Pre-application 1 Comments 2019

London Borough of Southwark Comments 23.03.2020

Planning History -Pre-application 1 Development 2020

Proposed revised atrium roof

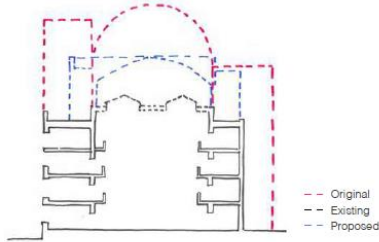
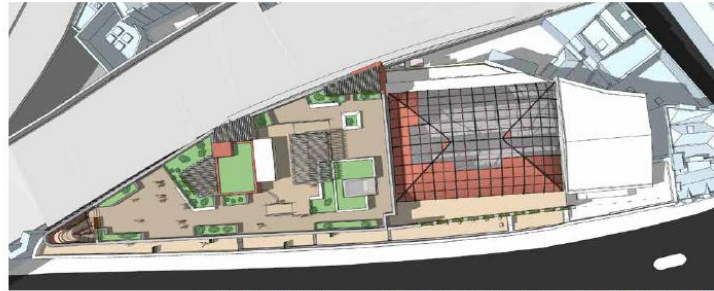
- “Changes to the Atrium - this space and the series of rooms accessed from it is the most significant piece of the Hop Exchange jigsaw. The clunky beams installed in the late 20th century have little aesthetic quality, and require a simple elegant solution which would enhance the interior of this space”

- Further information required in the application on materials and finishes. Oxide cladding needs further detail/justification.
- Atrium roof needs to be more elegant – further thought required but principle is acceptable.
- Details of joinery to be reviewed at application stage

- “We are pleased to see that the emerging roof design has responded to these recommendations in its elegant and understated vaulted form which celebrates the volume of this central part of the listed building. It is clearly an improvement on the existing 1960s structure, and appears to draw influence from the original demolished roof structure on the basis of the historic drawing provided in the document.” More work is required on the panelling positions

Proposed Front Elevation

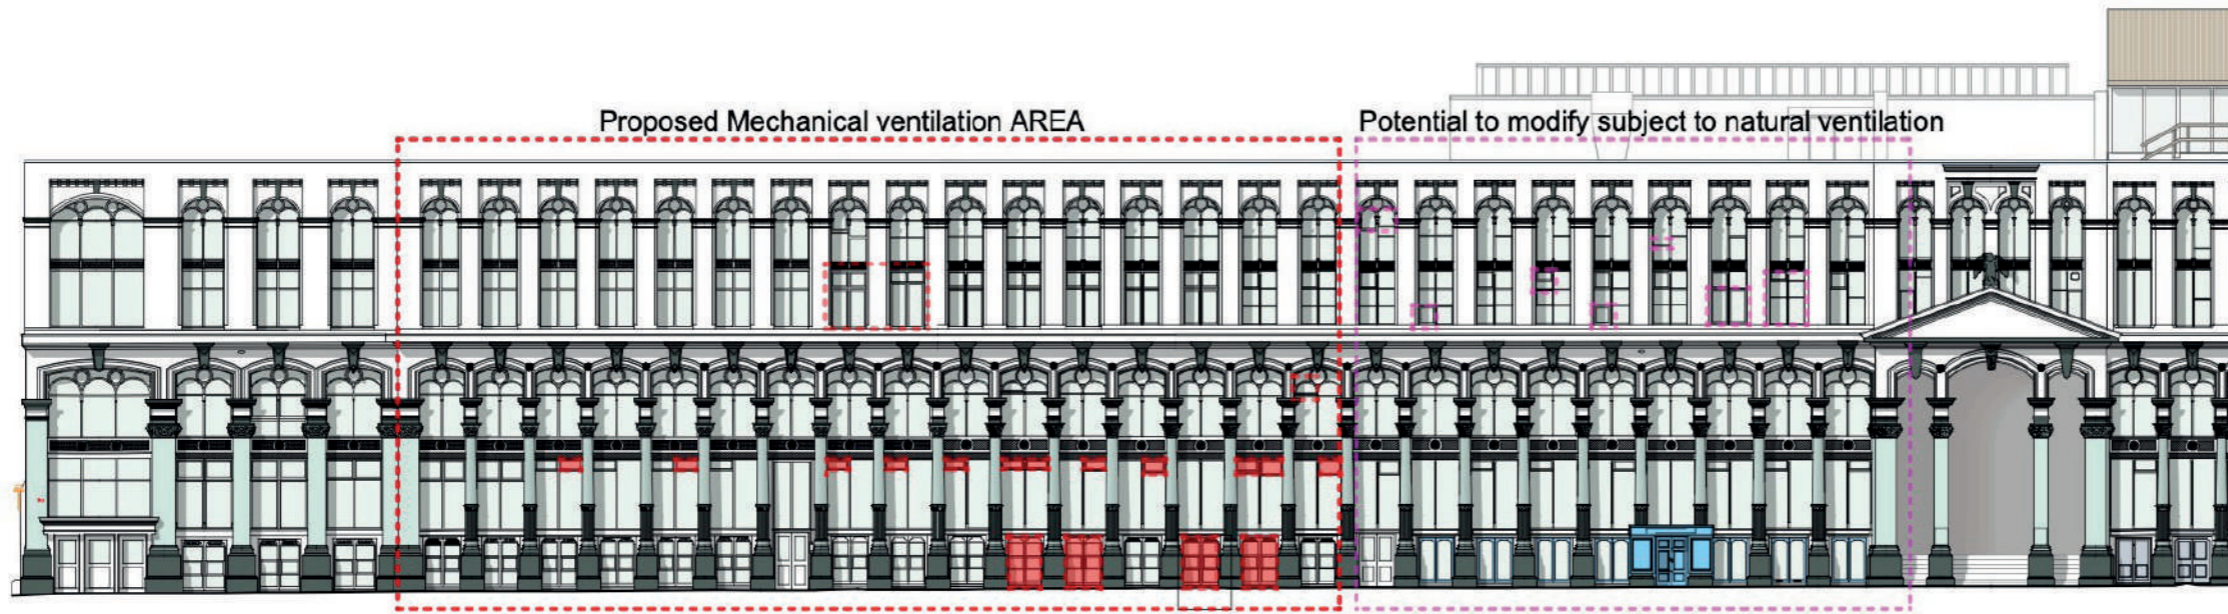
- Principle of Roof Extension acceptable
- Vertical/horizontal relations to be indicated
- Concern over the rear extension being too bold/bulky especially diagonal façade line
- More contextual relationship ties more closely to host building is required.
- Simplification of proportions.
- Atrium roof too contemporary more contextual relationship required
- Atrium focal point of listing.
- Simplification of glazing panels and colour.

- “We are pleased that the scheme as currently presented responds much more successfully to the orderly fenestration arrangement of the Hop Exchange, and of the many other commercial and industrial buildings found in this part of the Borough High Street Conservation Area.”

Exploring continuing the rhythm of the windows on the front facade to the rear by breaking the grid down slightly but still retaining strong horizontal and vertical elements

Pre app 2 Addendum developed rear elevation following historical study

3 Existing front elevation
Scale: 1:250

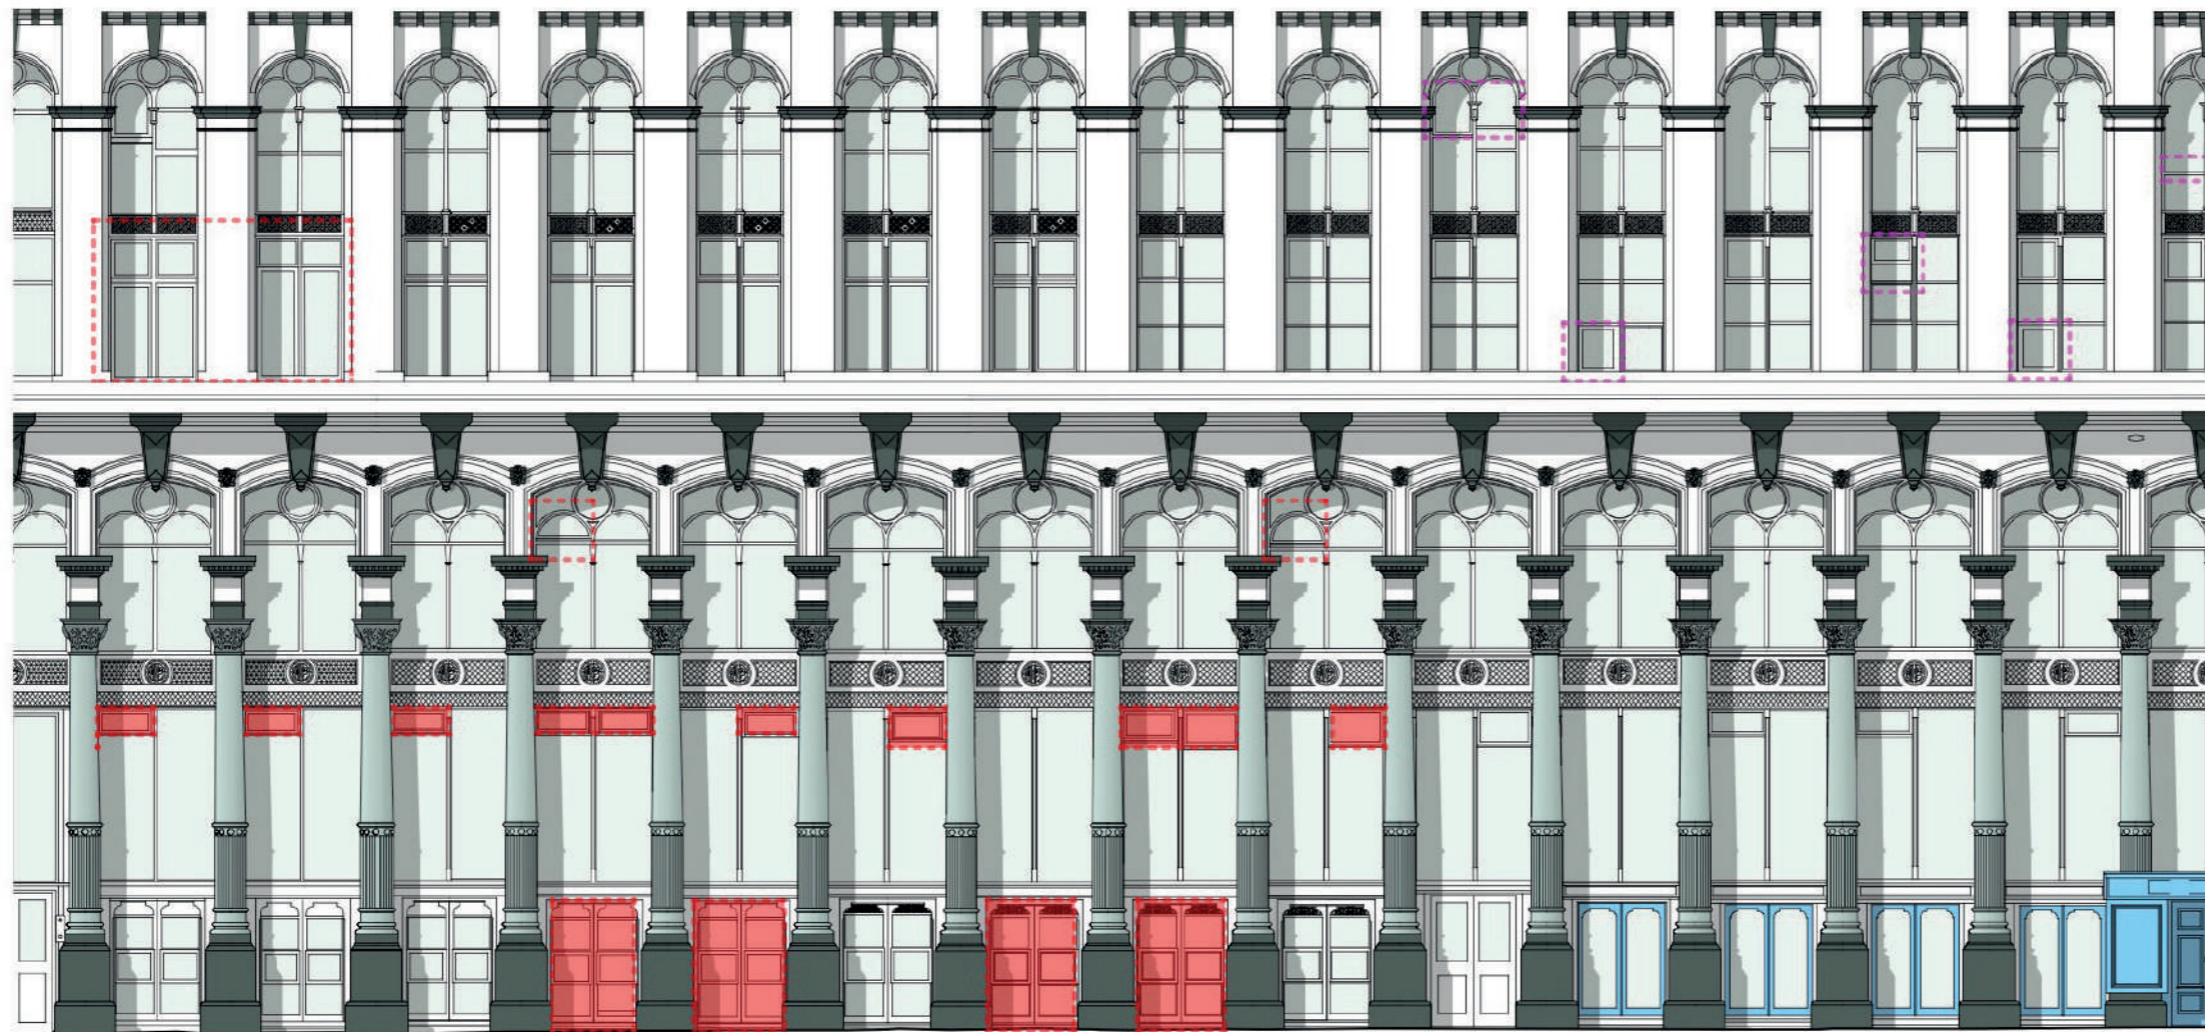
- “Historic England broadly welcomes these proposals which seek to enhance some of the building’s most important features such as its main façade and central hall. We also have no major concerns at this stage regarding the proposed roof and lightwell extensions, although more visual testing either at pre-application or application stage would be helpful. We would, however, encourage greater retention of historic features internally where possible”
- “exciting opportunity to enhance the significance of the elevation by reinstating the original fenestration arrangement and paint scheme based on the historic research that has been carried out”

# Appearance- Existing & Proposed view looking west down Southwark Street

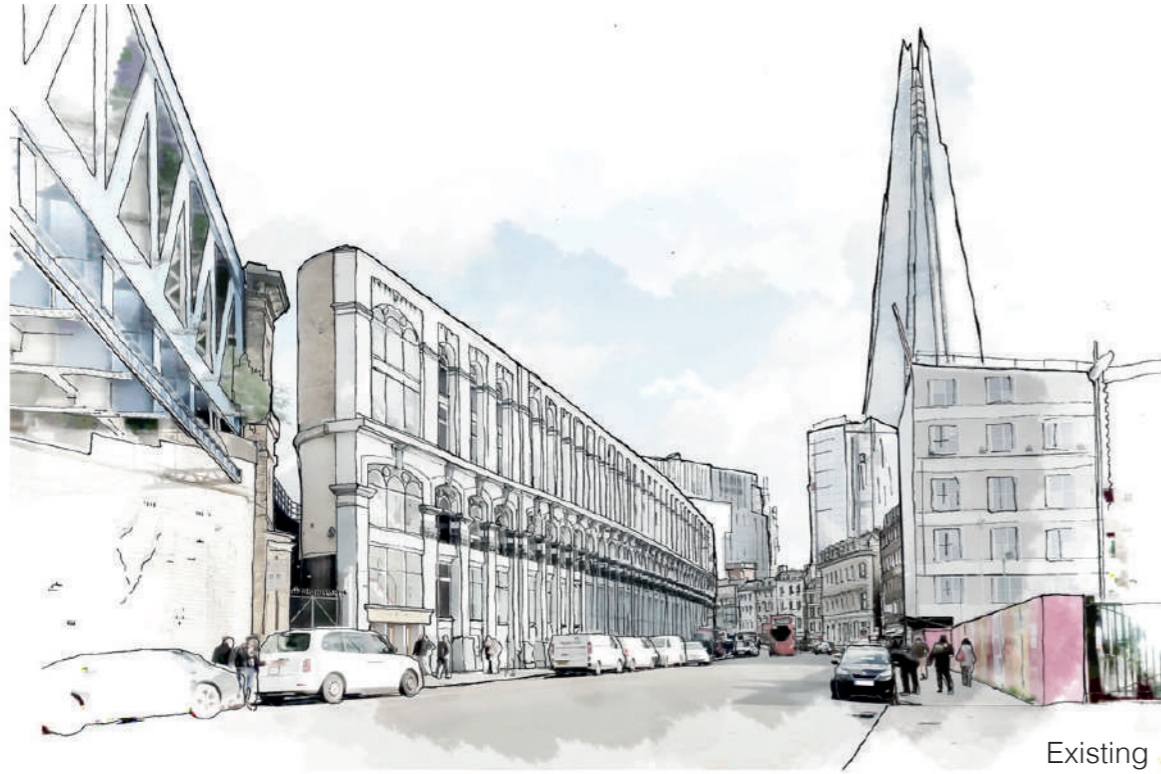
- “We maintain that we have no in-principle issues with the scale, massing or design of the roof extension at the front of the building. However we would encourage a more comprehensive visual assessment to be provided at application stage so we have a clear understanding of the visual effects on the Hop Exchange in views along Southwark Street.”
